**KIRKLEES METROPOLITAN COUNCIL
INVESTMENT & REGENERATION SERVICE**

Reference No:	2023/62/92894/W
Site Address:	19, Holly Road, Thornton Lodge, Huddersfield, HD1 3SE
Description:	Erection of front and rear dormers
Recommending Officer:	Joanna Rednall

HOUSEHOLDER DELEGATED REPORT

South Elevation (Rear) 1.100

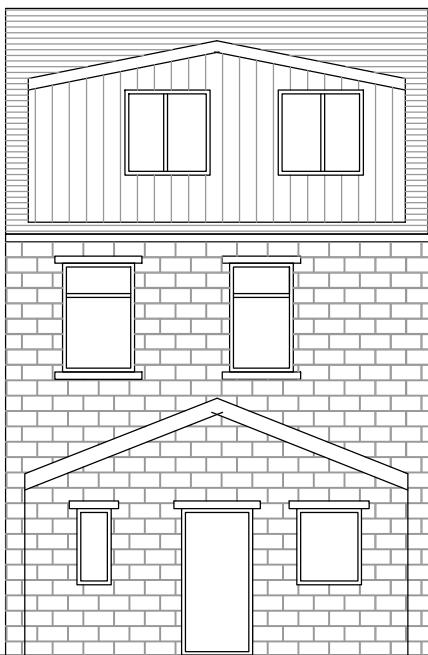
Relevant key design principle (KDP) of the SPD, Policy in the Kirklees Local Plan and the NPPF	Further comments	✓ / X / N/A
Impact on the Local character and street scene	• KDP1 of the SPD • Policy LP24 Design (a) and (c) of the KLP • Chapter 12 NPPF	Would introduce an interruption to the linear roof slope however the property hosts full Permitted Development rights for the rear dormer and the front dormer is small in scale	✓
Impact on original house	• KDP2 of the SPD • Policy LP24 Design (c) and (d) of the KLP • Chapter 12 of the NPPF	Original roof form would be clearly visible to the front.	✓
Height, scale and massing	• KDP 1 and 2 of the SPD • Policy LP24 Design (a), (c) and (d) of the KLP • Chapter 12 of the NPPF	Front dormer would not dominate the roof or project above the roof of the host property. The proposed dormers are set below the ridgeline of the existing roof a within the roof plane. PD rights exist for a rear dormer of similar scale. Whilst large, this is afforded significant weight.	✓

Chapter 12 of the NPPF		
Roof style	- KDP 1 and 2 of the SPD - Policy LP24 Design (a), (c) and (d) of the KLP - Chapter 12 of the NPPF	Gable roofed to match host property, flat roof to the rear dormer (pd right fallback)	✓
Window proportions	- KDP 1 and 2 of the SPD - Policy LP24 Design (a), (c) and (d) of the KLP - Chapter 12 of the NPPF	Windows do not align with the windows in the ground and first floor, but would not cause an unduly detrimental appearance.	✓
Accessibility for all users	- KDP 17 of the SPD - Policy LP24 Design (f) - Chapter 12 of the NPPF	Private domestic extension. No alterations to access.	✓

3. The external walls (face and cheeks) of the dormers hereby approved shall be first clad in dark grey cladding to harmonise with the existing roof slates. The pitched roof of the front dormer shall be laid with blue slates to match the host dwelling. The cladding and roofing materials so approved shall thereafter be retained.
